SSD-10461: Valley of the Winds, Warrumbungle Shire Council

3 August 2022

TfNSW has reviewed the documentation including (but not limited to) the *Traffic Impact Assessment* (TIA), prepared

SCALE	1:500	REVISION	08	VALLEY OF THE WINDS		
DESIGNED	TB	CHECKED	BS	GOLDEN HIGHWAY / GIRRAGULANG ALTERNATE ACCESS ROAD		
DRAWN	TB	CHECKED	BS	DETAIL PLAN - ALTERNATE ACCESS		
APPROVED		DATE		SHEET 3 OF 3		
SIGNED				PROJECT NO	SHEET NO	STATUS
				BTE-220034	SHT-06-RW-0153	STRATEGIC DESIGN

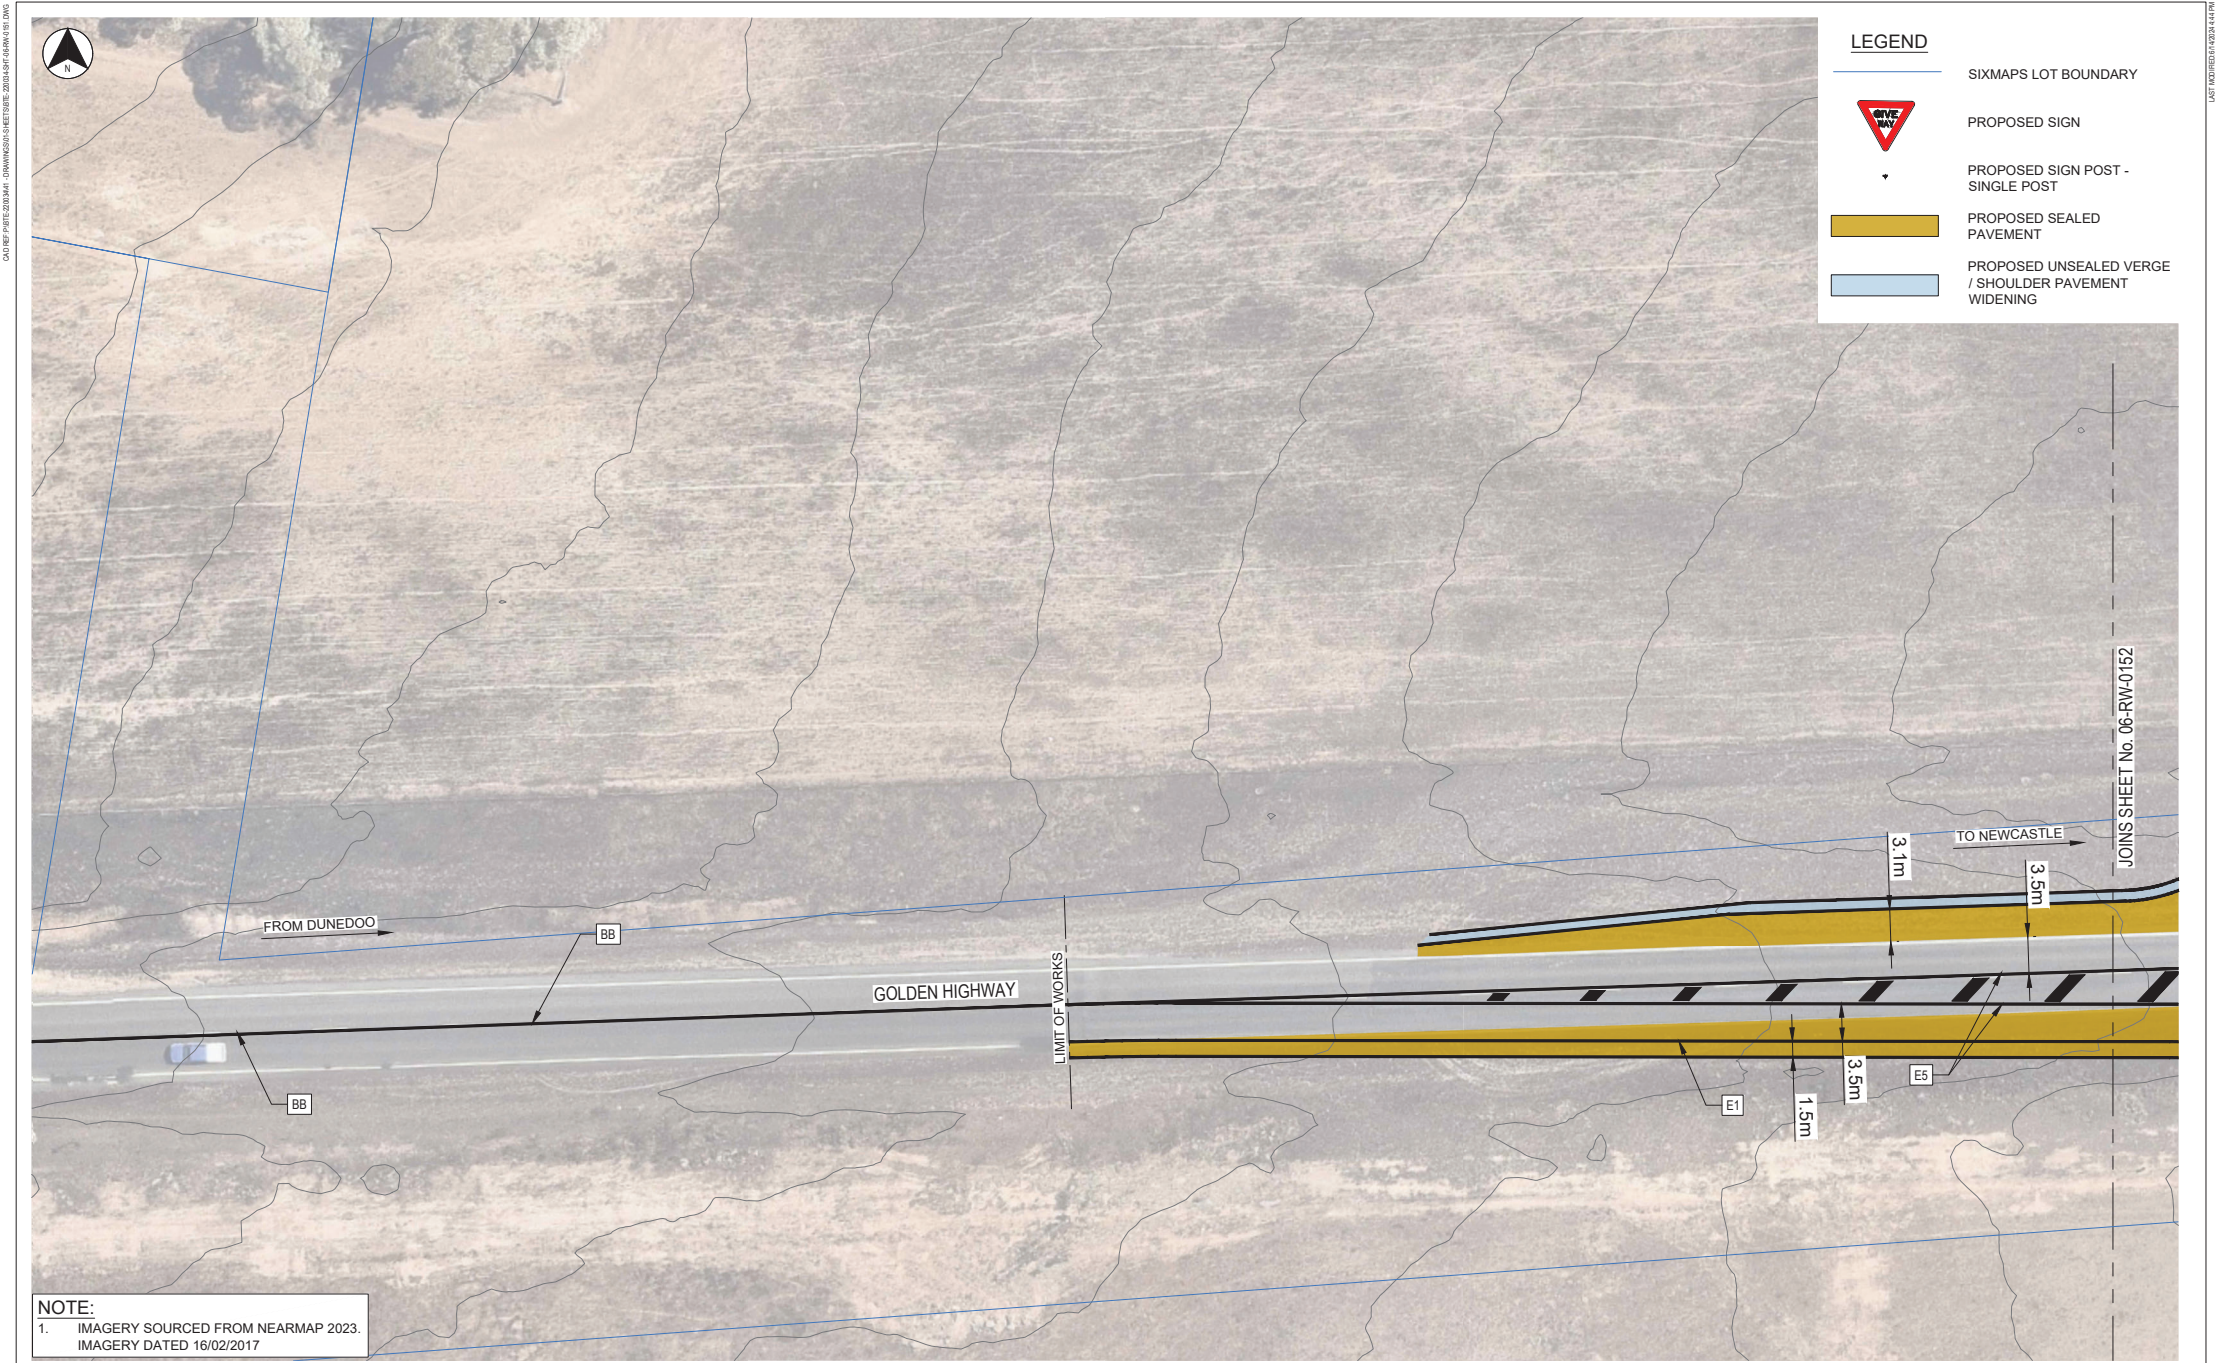
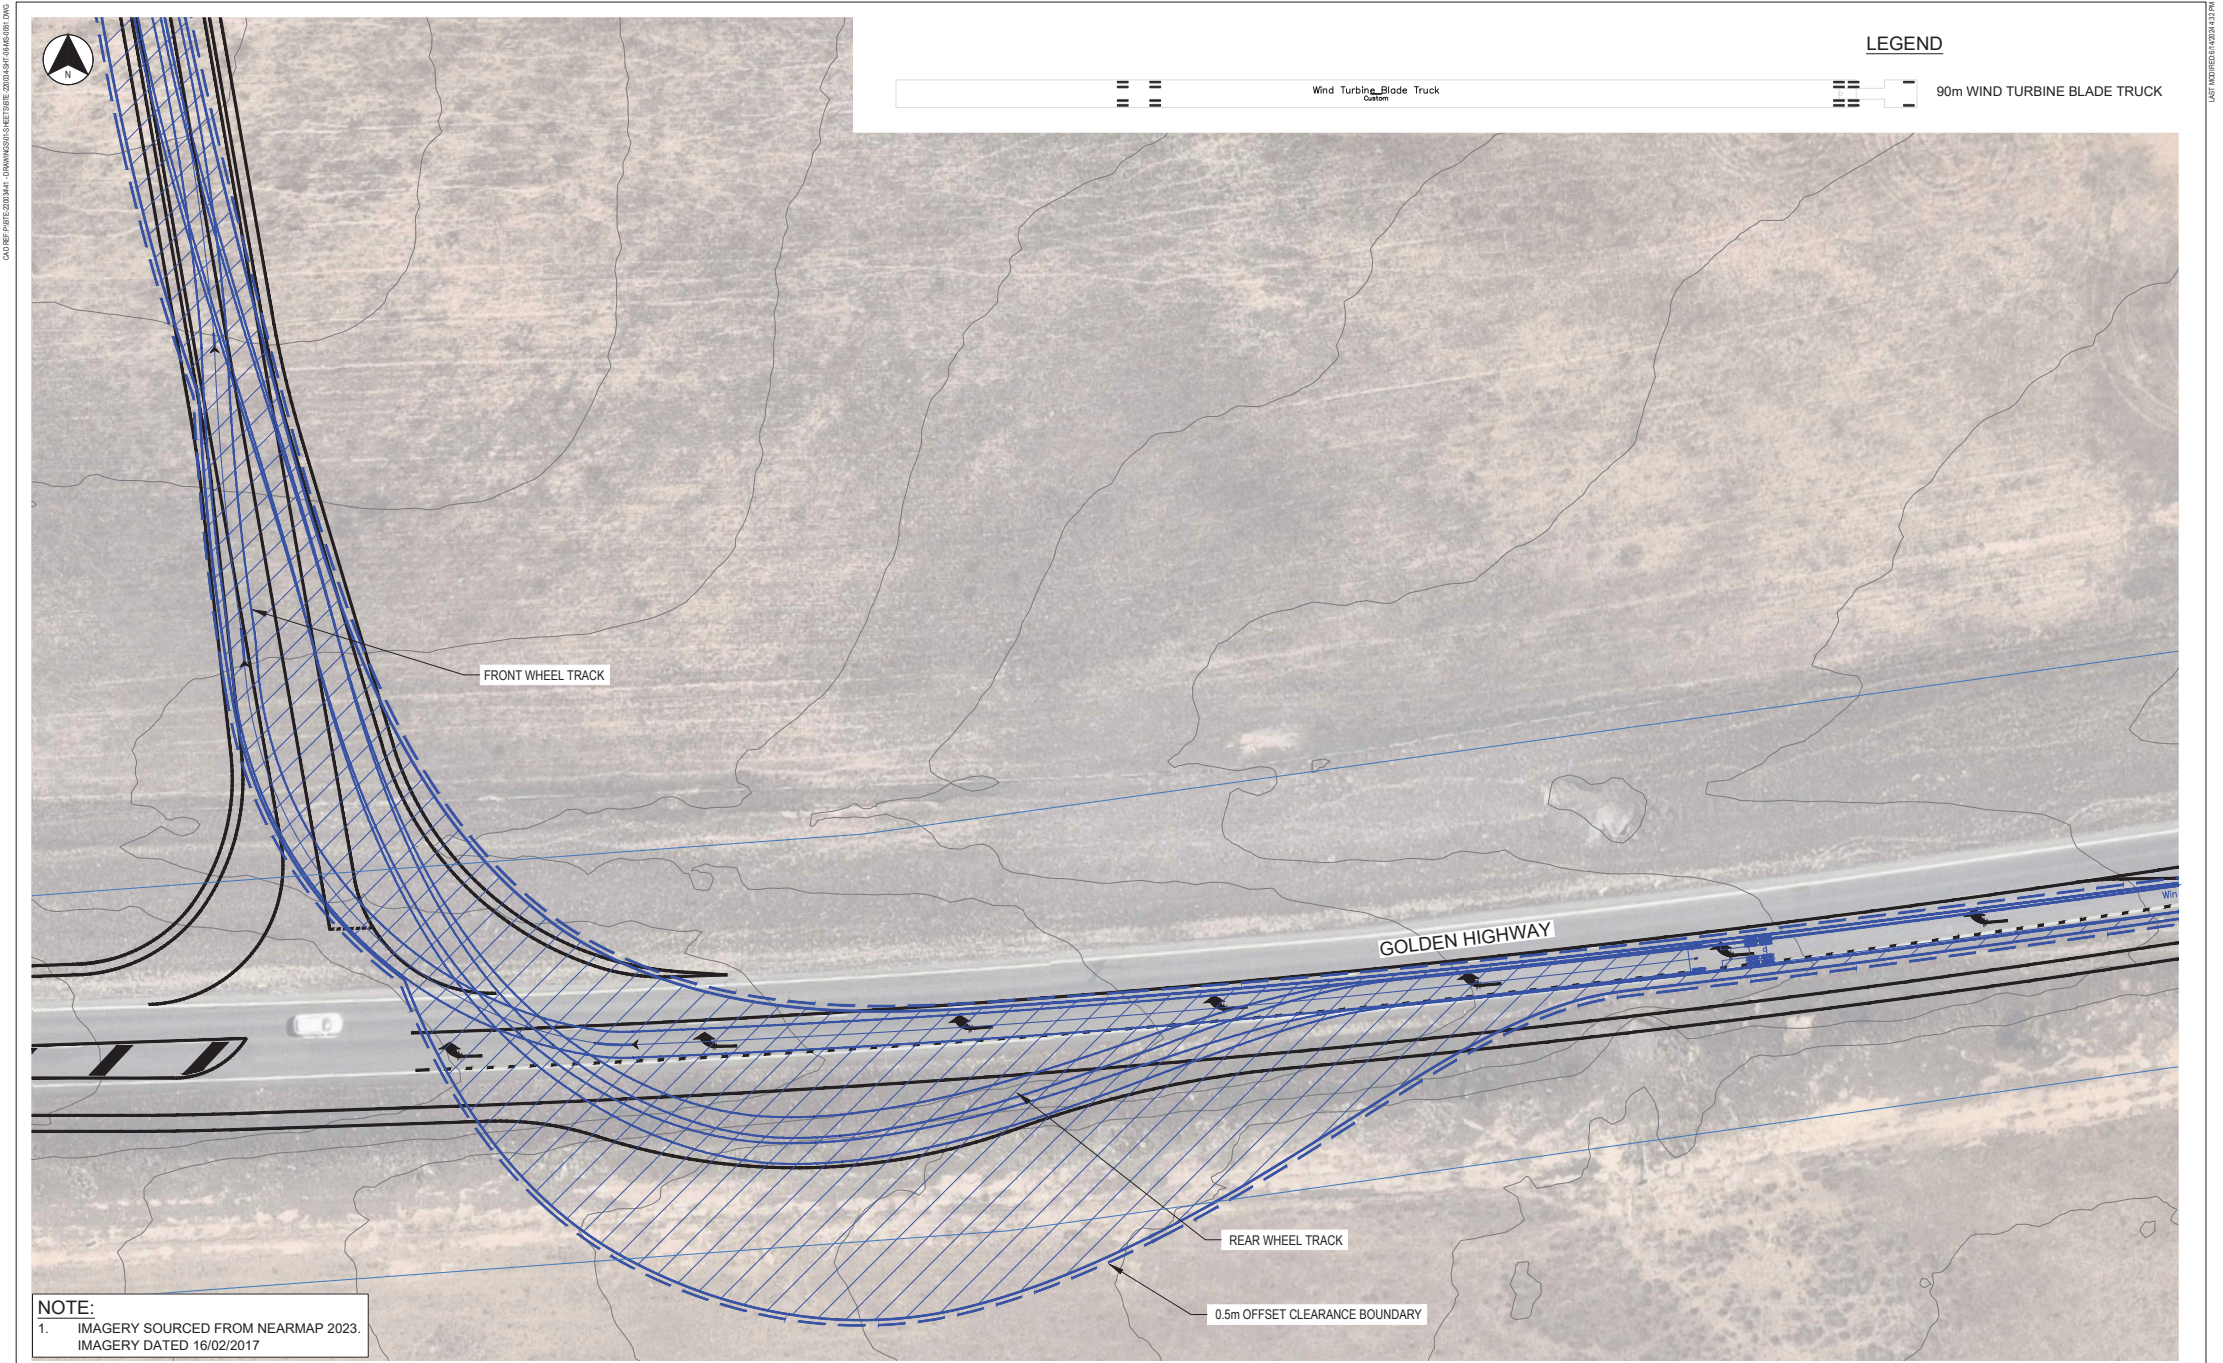
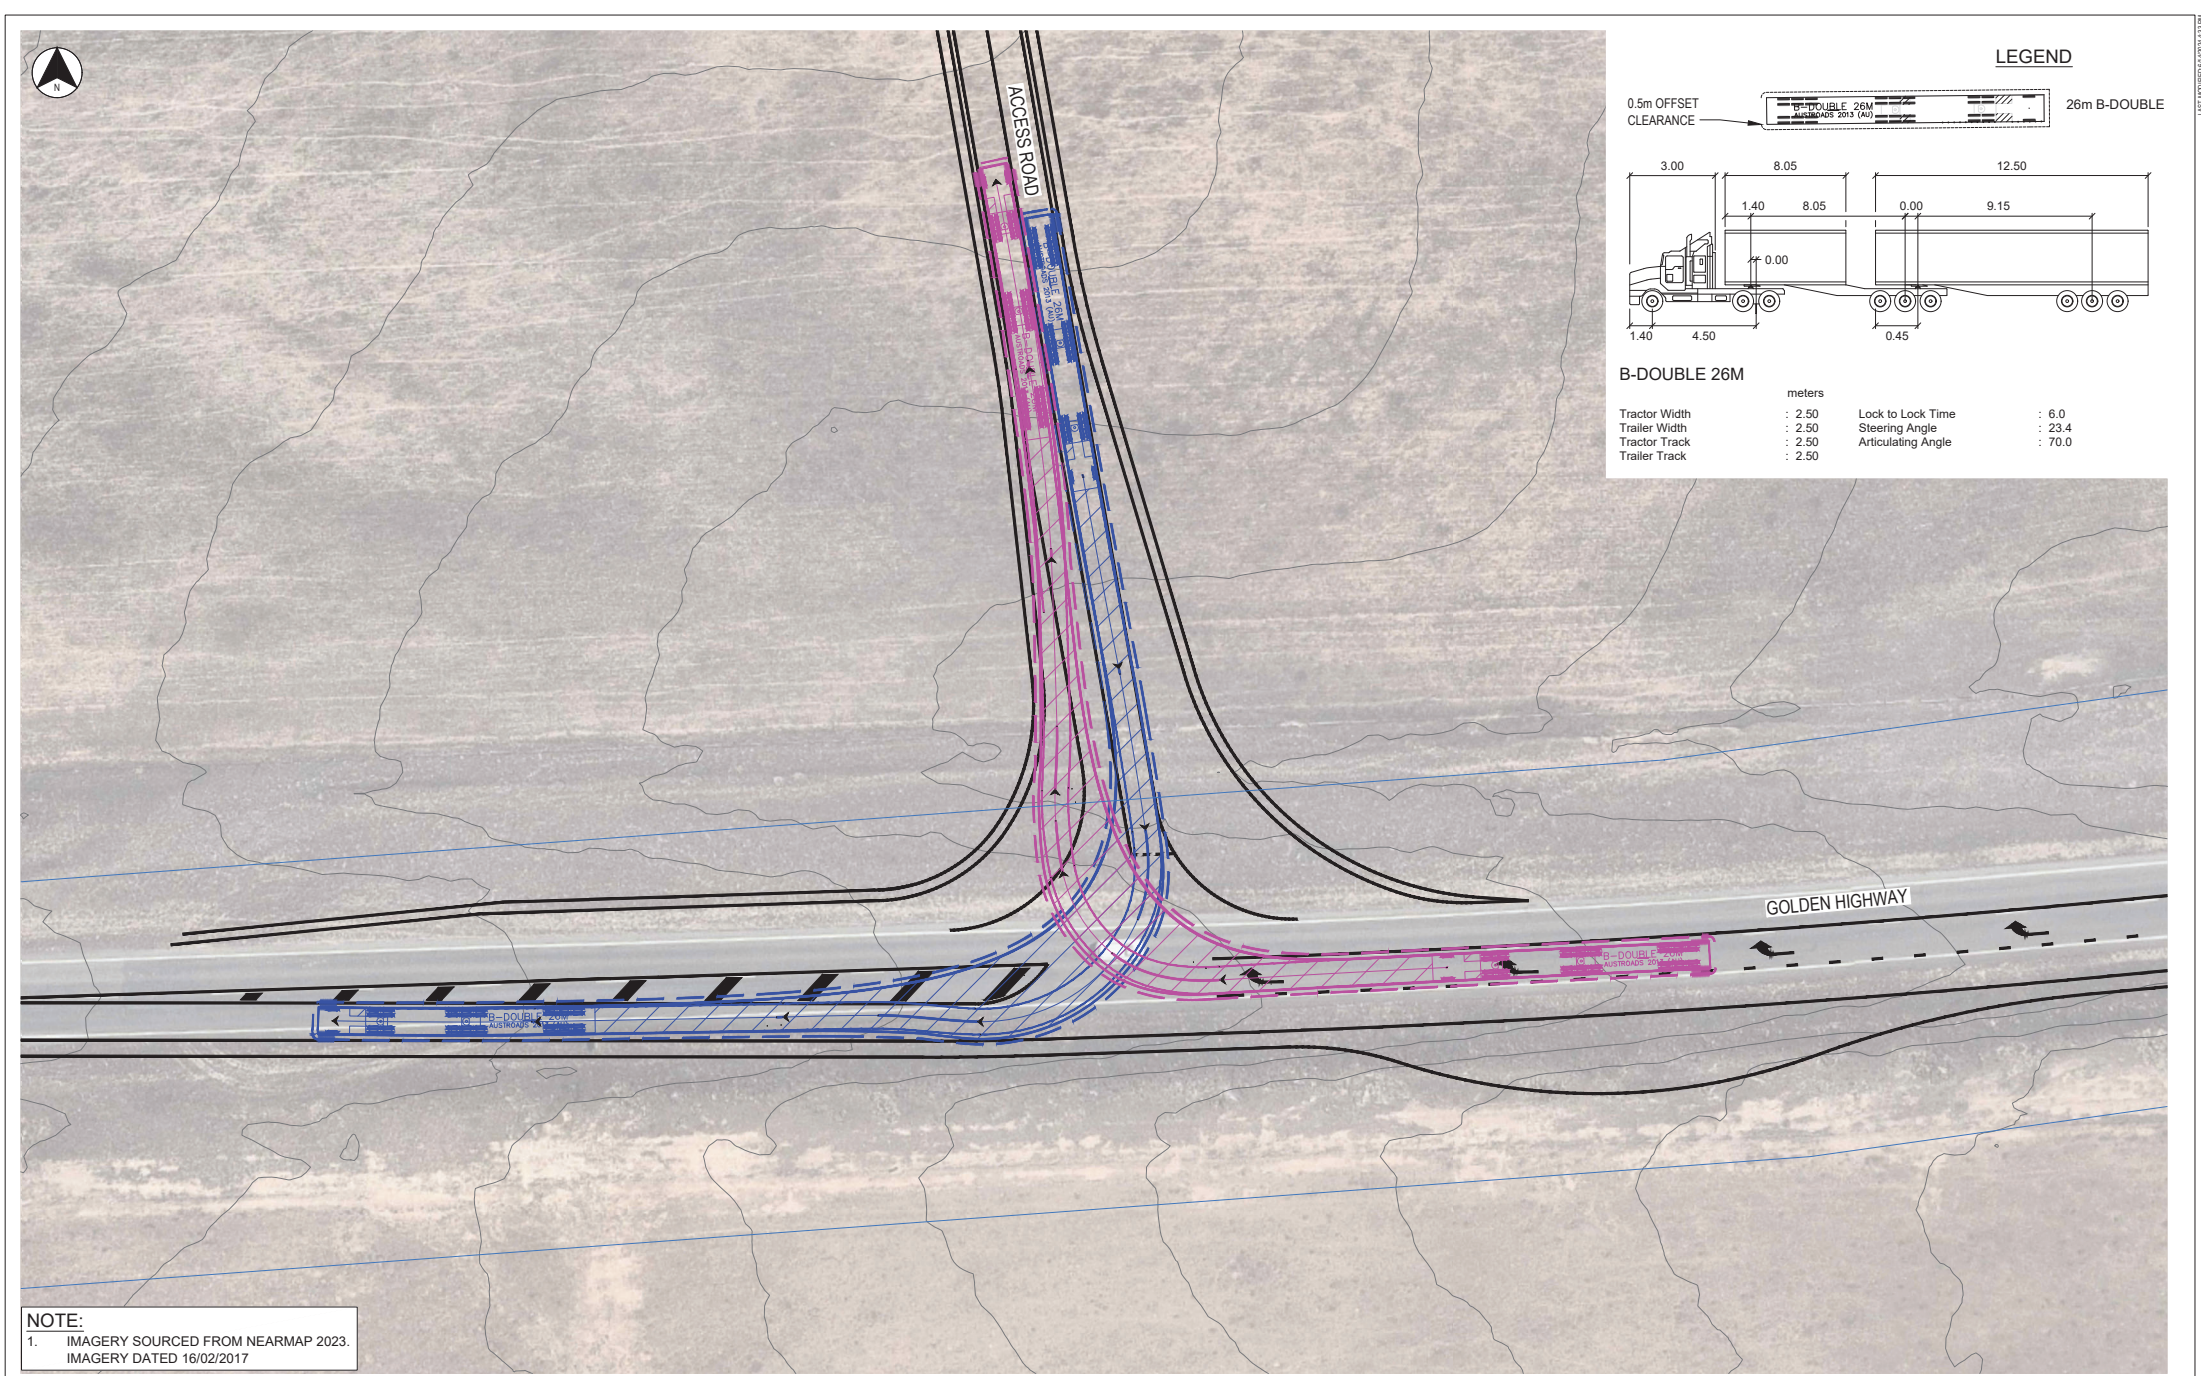
- Reconsideration of the proposed minimum BAR/BAL intersection treatments along the Golden Highway, noting the high percentage of heavy vehicle traffic on the major freight route and the high-speed limit (i.e. 85th percentile is likely to be higher on the rural road than the signposted speed). The TIA shows that right-turns associated with AM peak construction traffic at the Golden Highway / Leadville Access (both access locations for Leadville cluster) and Golden Highway / Short Street (Girragulang cluster) are considerably greater than existing traffic movements.
